| PROJECT NO. 1002186                   | APPLICATION NO. 020RB 01320 |
| PROJECT NAME Atlantic & Pacific Add.  |                             |
| <b>ONE STOP COMMENT FORM LOG</b>      |                             |

RE: Replat of Lots 9 and 10, Block X, Atlantic and Pacific Addition

PLAT OF
LOT 10-A, BLOCK X
ATLANTIC AND PACIFIC ADDITION
ALBUQUERQUE, BERNALILLO COUNTY, NEW MEXICO

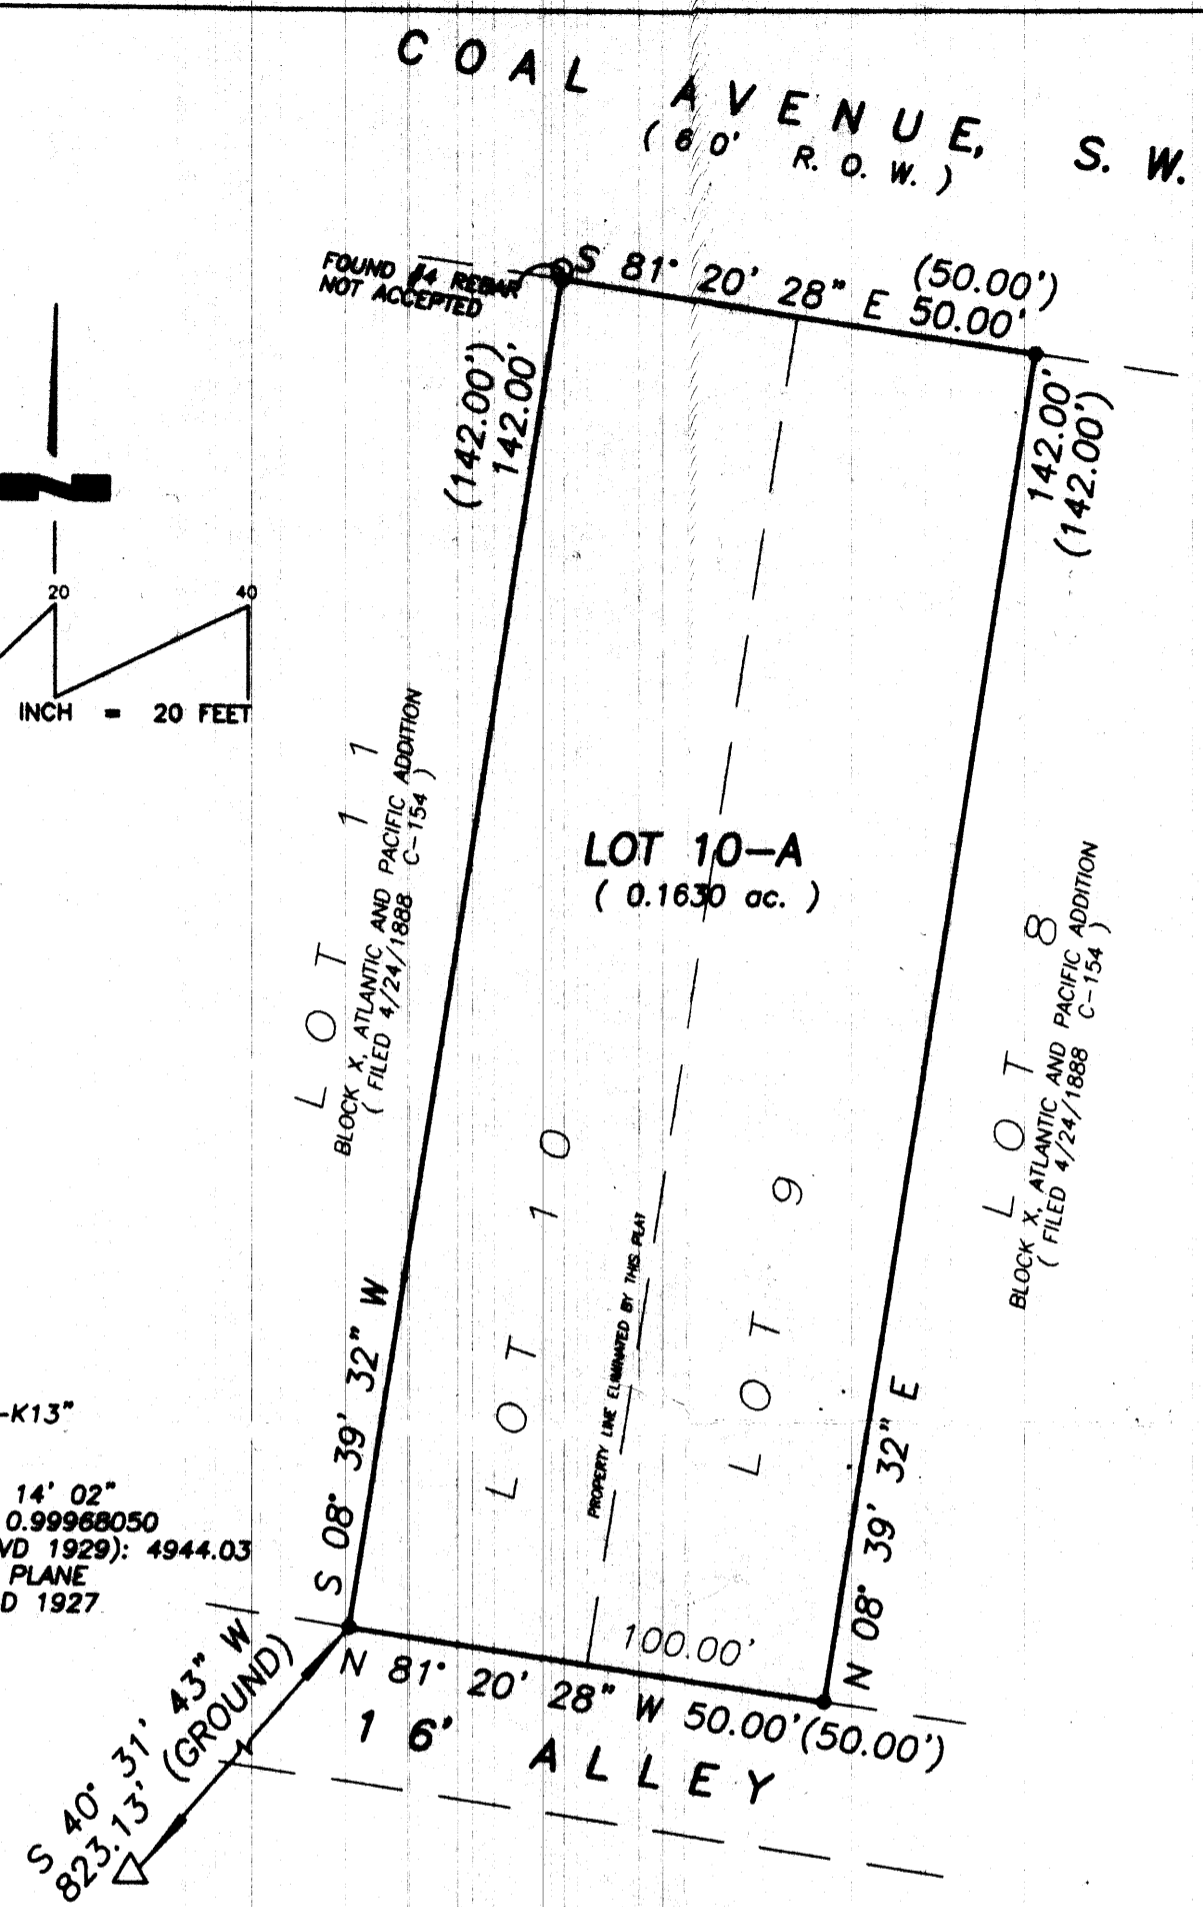
| 1- NEED TO DEDICATE 10' from face of curb on COAL. |                                 |      |

| <p>① minor plats (not completing a vacation) may be recorded by the applicant/agent. A copy of the recorded plat must be provided to Planning in order to close the case file. ② Please provide a digital dxf file showing easement parcel and right-of-way lines in New Mexico State Plane Feet NAD 1927 or 1983 for AGIS purposes. This information may be emailed to jmsorley@cabq.gov or provided on a disk.</p> |              |      |
